# Objection Submission

To: NSW Department of Planning, Housing and Infrastructure – Major Projects Assessment Team

Re: Development Application SSD-82709458 – 19–25 Balfour Street, Lindfield NSW 2070

Submitted by: Jian Jin, Owner of 1 Wallace Parade, Lindfield NSW 2070

Drawings:
**OVERSHADOWING DIAGRAMS
(PROPOSED)**

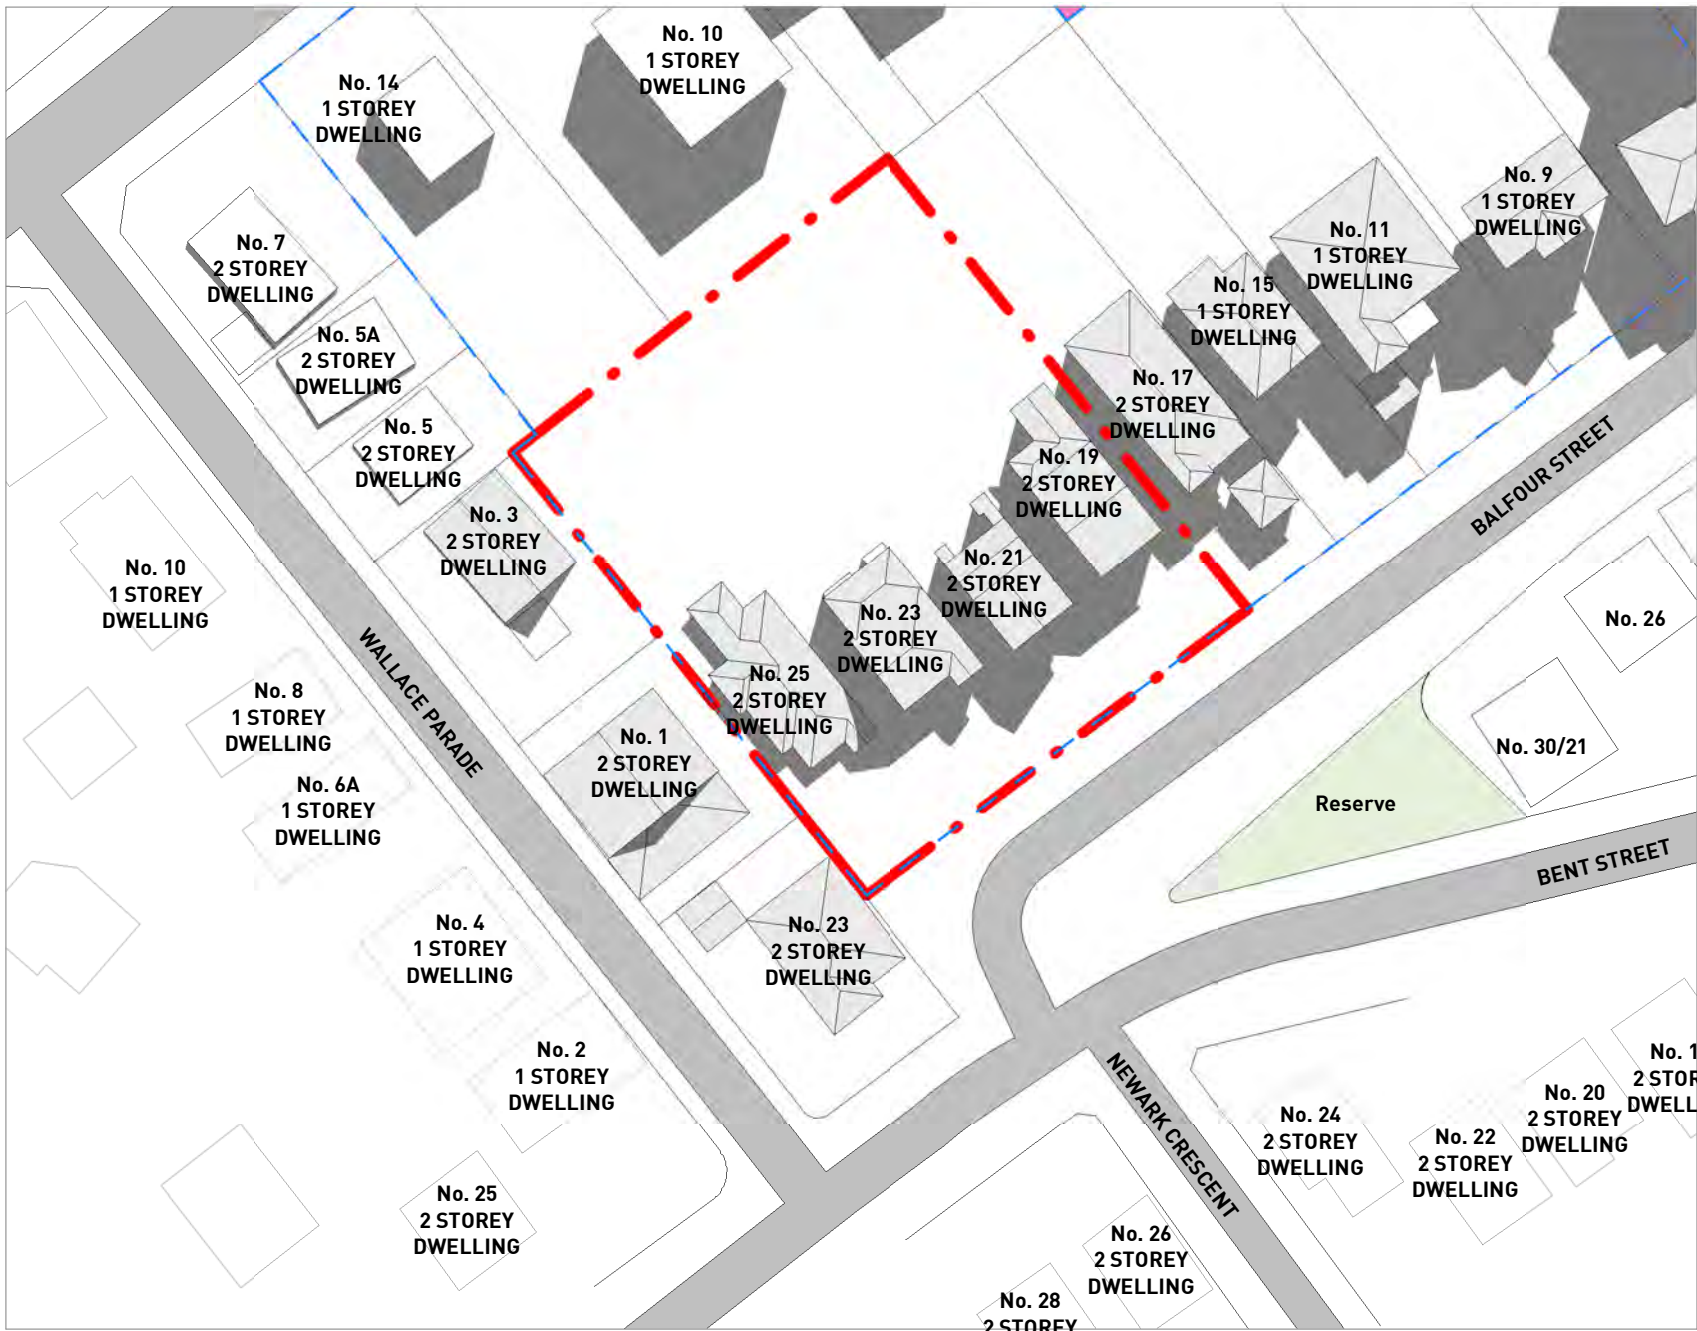
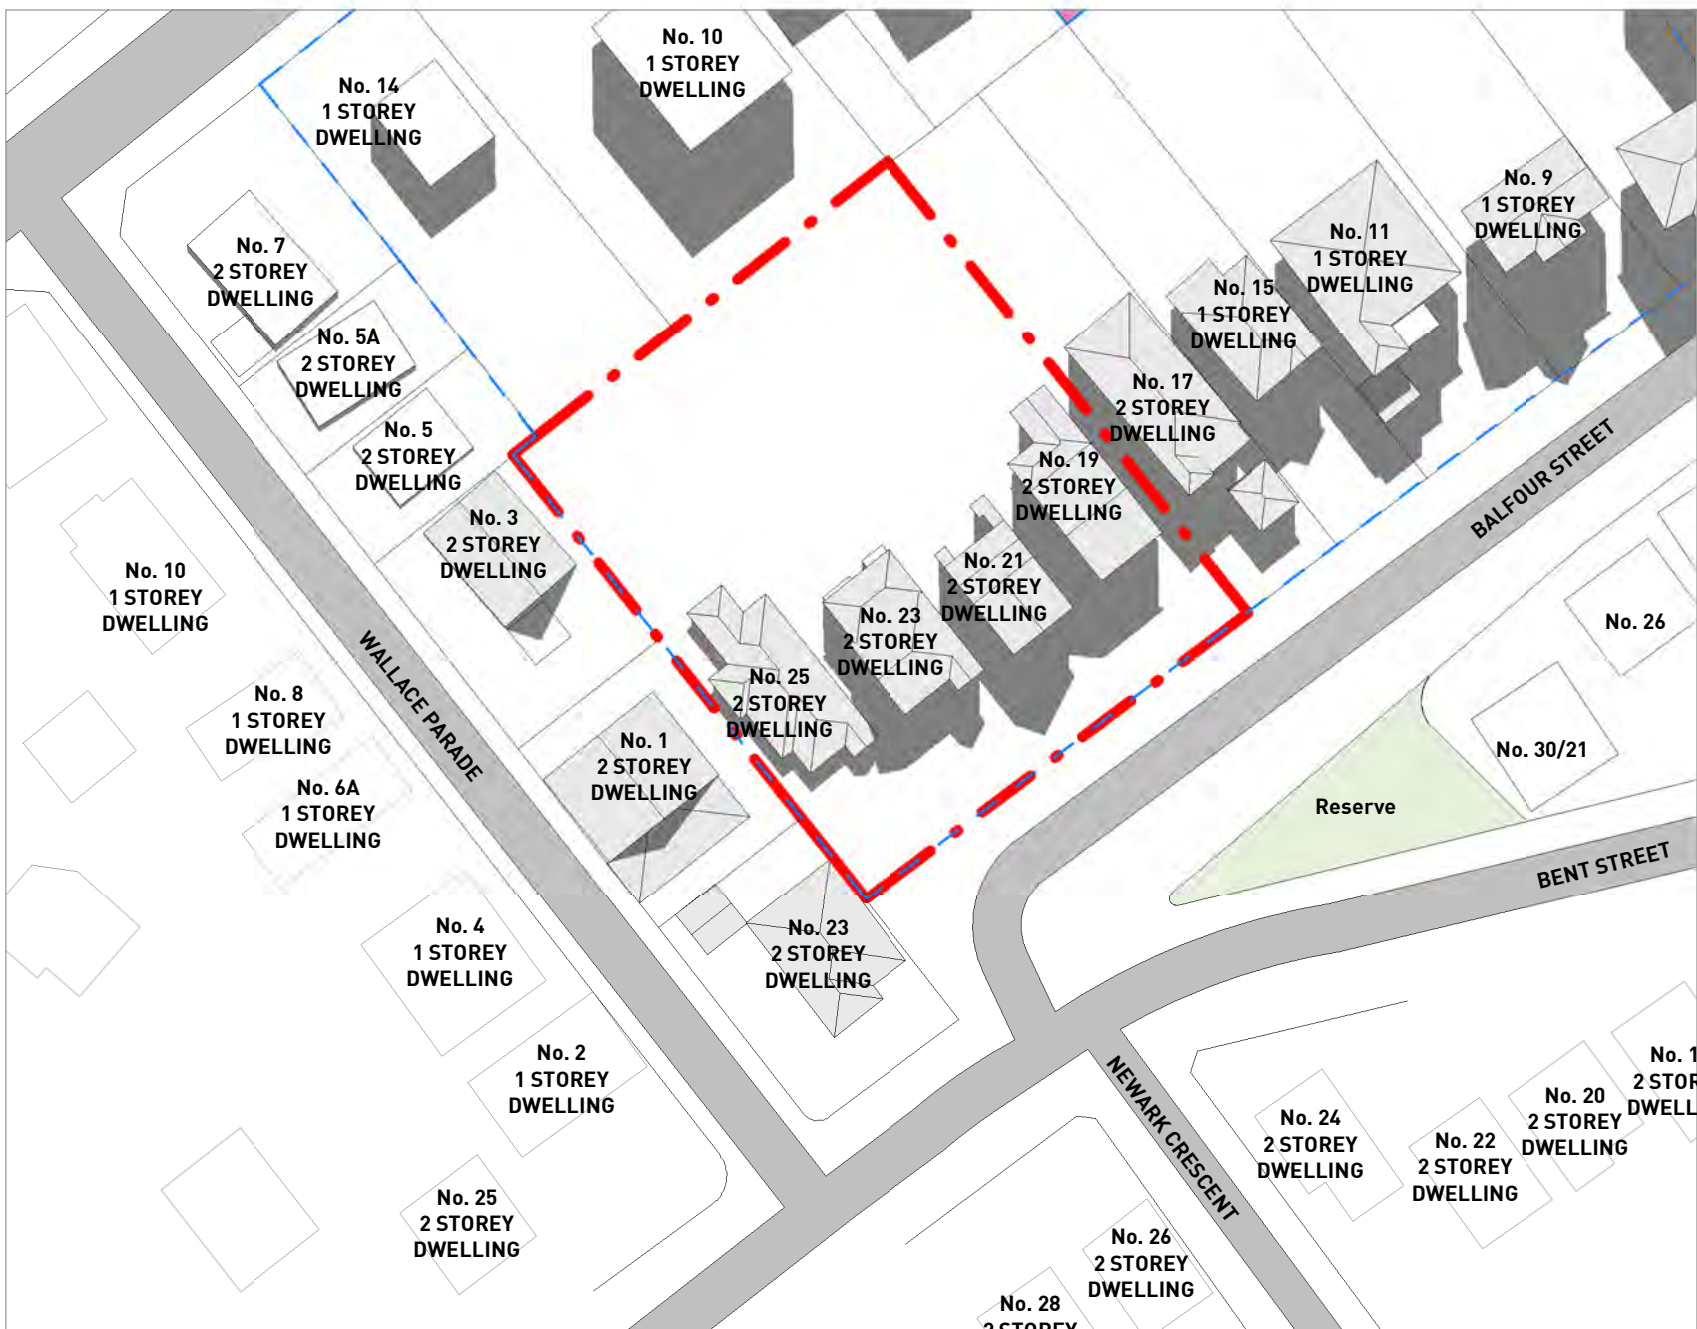
- The applicant’s shadow diagrams show that during winter solstice (22 June), surrounding low-density dwellings, including my property at 1 Wallace Parade, would not achieve the minimum three hours of direct sunlight between 9:00 am and 3:00 pm as required by the Apartment Design Guide (ADG, Objective 3B-2).
- With a proposed height of 32.7m, the building substantially exceeds the R2 low-density residential context, creating an excessive overshadowing effect.
- Long-term loss of sunlight would reduce amenity, increase winter heating demand, impair natural ventilation, and inhibit vegetation growth. Land and Environment Court precedents have recognised severe overshadowing as an unacceptable environmental impact that justifies refusal.
